Rezoning Transportation Analysis

Petition Number: 2021-177

Date	Description
11-21-2021	First Review (PDM)

SHEET NUMBER:
 RZ-1

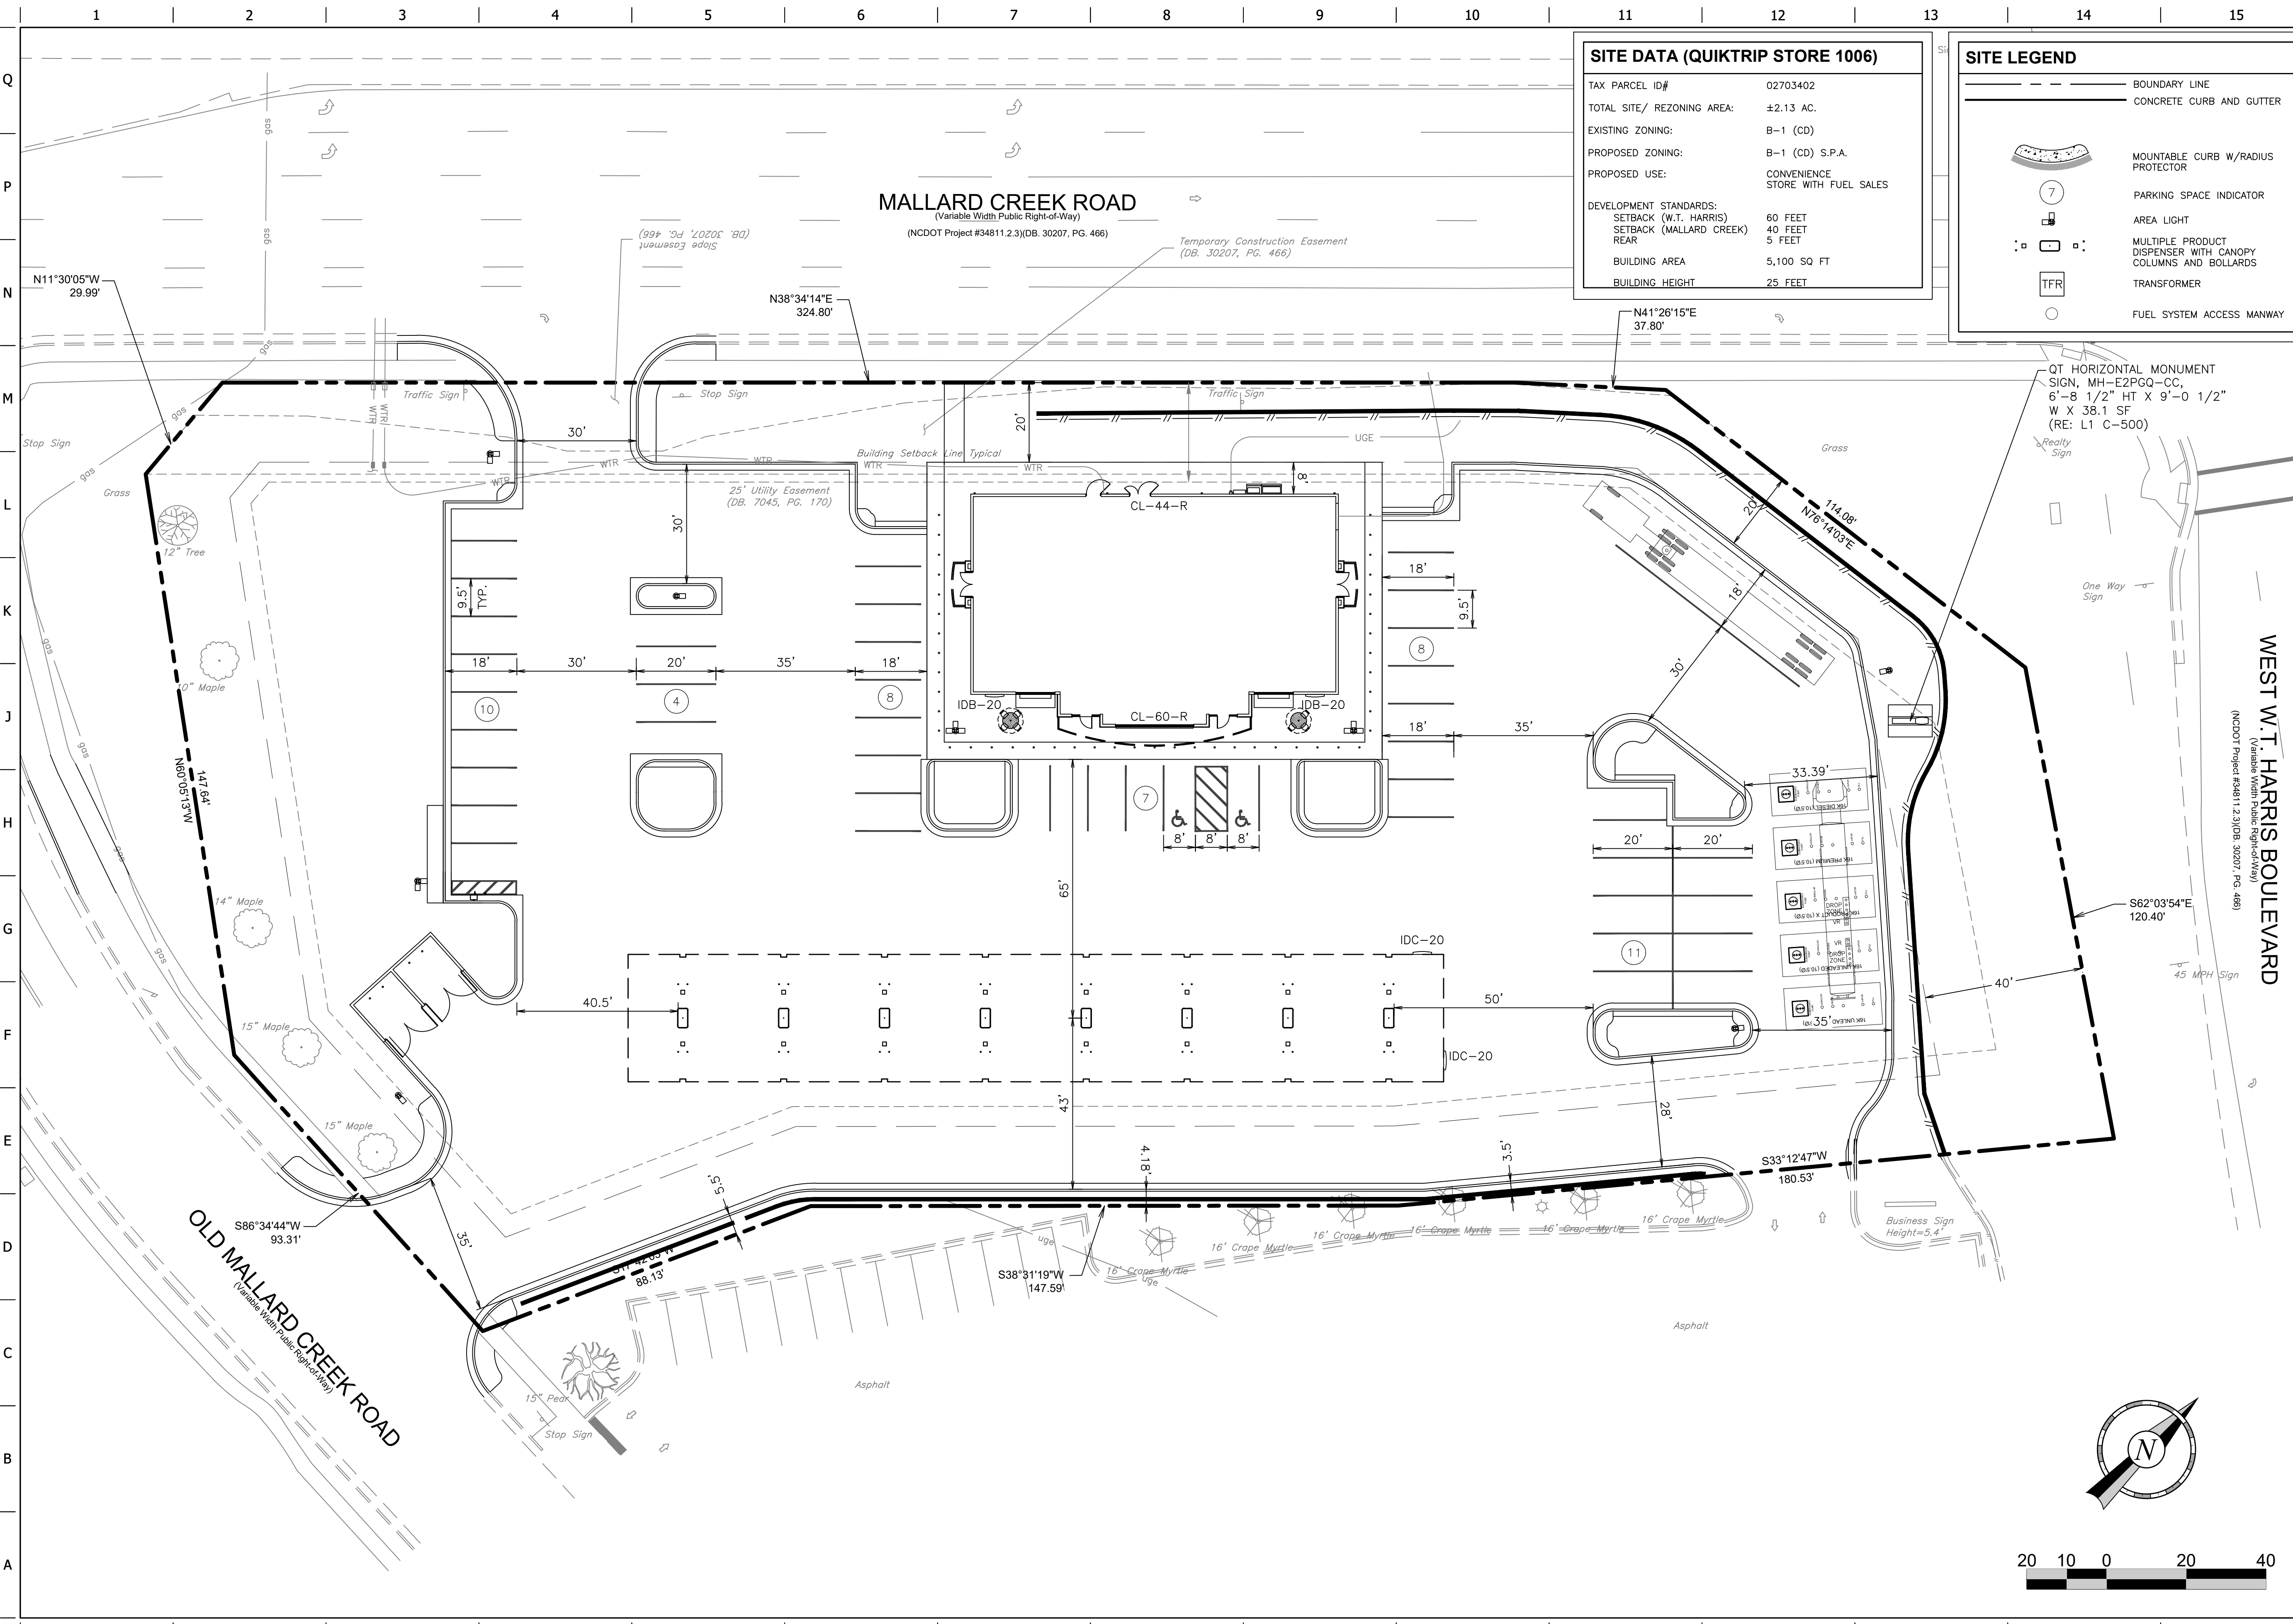
1. **Curblines:** The proposed zoning district has a setback measured from back of the existing or proposed future curblines.

a. **WT Harris Blvd:** The future location of curb and gutter will be 53-feet measured from the centerline to the back-of-curb.

b. **Mallard Creek Rd:** Location of the future curb and gutter is in the existing location.

c. **Old Mallard Creek Rd:** Location of the future curb and gutter is in the existing location.

Label and dimension the curb and gutter from the centerline for each road on the site plan. Coordinate with NCDOT regarding the installation of curb on WT Harris Blvd along the property frontage.

3. Revise site plan to label and dimension the right-of-way from the road centerline.

4. Revise site plan to show Control of Access on WT Harris Blvd. Confirm with NCDOT

5. Revise site plan and conditional note(s) to commit to construct an 8-foot planting strip, and 12-foot multi-use path on Mallard Creek Road per Chapter 19. The site plan shall label and dimension both items from the back of curb and gutter and road centerline.

6. Revise site plan and conditional note(s) to commit to construct an 8-foot planting strip, and 6-foot sidewalk on Old Mallard Creek Road per Chapter 19. The site plan shall label and dimension both items from the back of curb and gutter and road centerline.

7. Revise site plan and conditional note(s) to commit to construct an 8-foot planting strip, and 12-foot multi-use path on WT Harris Blvd per Chapter 19. The site plan shall label and dimension both items from the back of curb and gutter and road centerline. This item must be coordinated with NCDOT

8. A site plan note(s) specifying dedication and fee simple conveyance of all rights-of-way to the City before the site's first building certificate of occupancy is issued as needed. CDOT requests rights-of-way set at 2' behind back of sidewalk where feasible.
